February 14, 2025

**Re: [#2023123] - Mountain Rd. Rehab Facility**

Transmitted herewith is an electronic copy of the FINAL Traffic Impact Study for your review and approval of the Referenced project. I have addressed your comments in your letter dated August 26, 2024 as follows:

**SP-1**

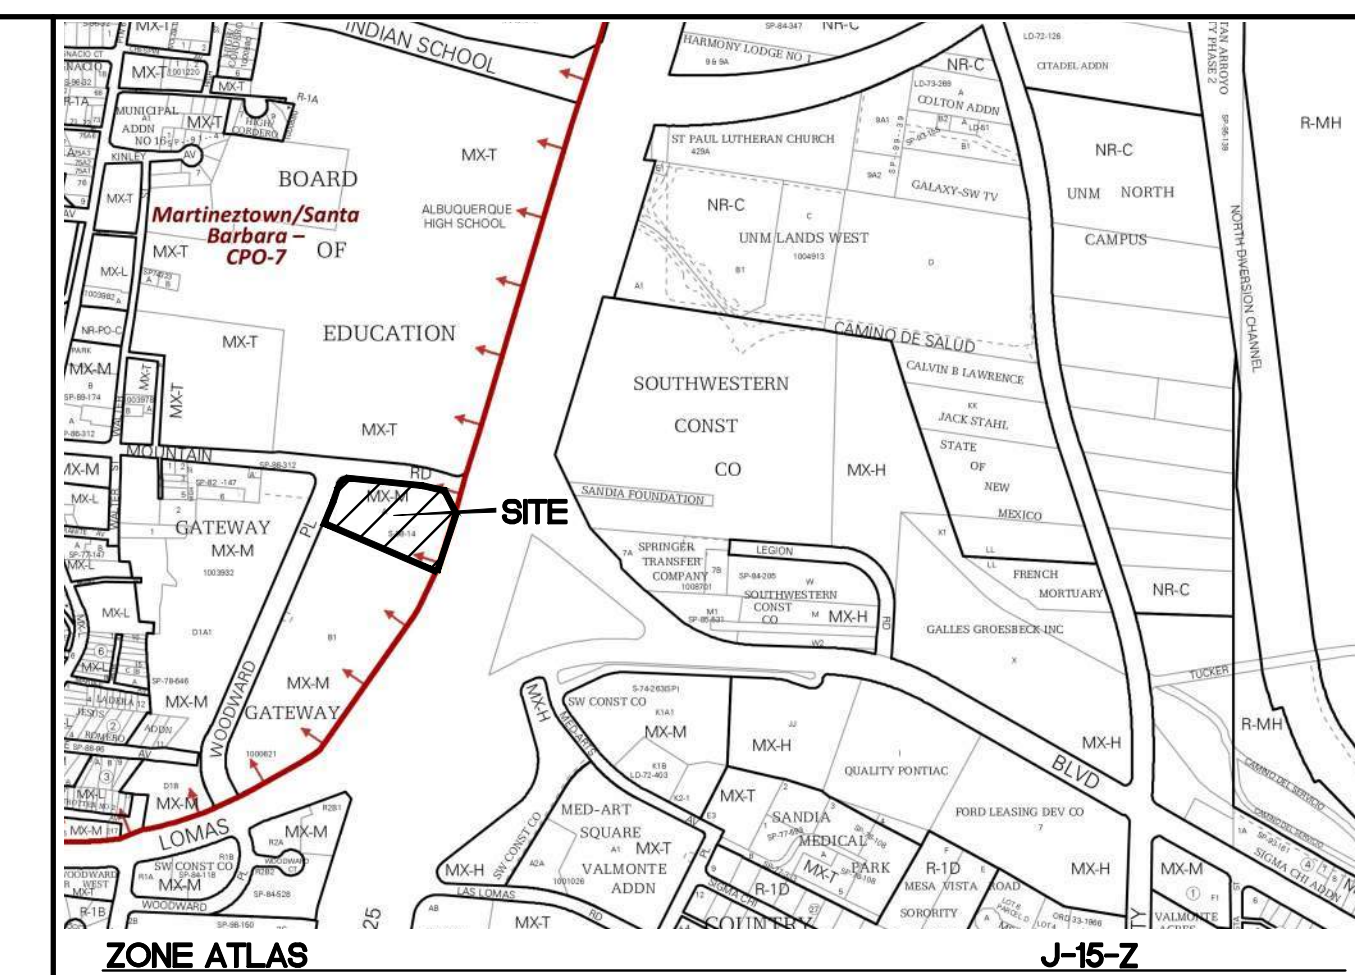
**Comment 3:** Page 3 – The original request was one access on Mountain OR full access via Embassy Suites easement. The request is now three access points. NMDOT recommends access to be limited to one access point. Please provide additional support for request of three access points.

**Comment 4:** Page 4 – How is the development accommodating bicycle traffic on Mountain?

**Response:** The proposed right-in, right-out driveway on Mountain Rd. (Driveway "B" in the Traffic Study / Safety Study) is located approximately 300 feet west of the I-25 W. Frontage Rd. Thus it meets the minimum criteria established in the City of Albuquerque's Development Process Manual (DPM) in Table 7.4.45 (Minimum Distance Between Commercial Site Access and Intersection) and Table 7.4.46 (Maximum Number of Commercial Site Access Points per Site). It seems prudent to assume that the tables in the City of Albuquerque DPM require the spacing of access for the primary purpose of providing safe access to a project. Therefore, we maintain that the proposed driveway on Mountain Rd. is safe and the developer desires the driveway to serve their facility. Additionally, Mountain Rd. is classified as a collector roadway on the Mid-Region Council of Governments' Futures 2040 Long Range Roadway System Map. As a collector road with a posted speed limit of 25 MPH, the proposed Driveway "B" also meets the NM DOT's criteria (Table 18.C-1 – Access Spacing Standards for Intersections and Driveways) for minimum driveway spacing.

**Response:** The revised site plan shows that the bicycle lane on Mountain Rd. will be striped along the frontage of the project.
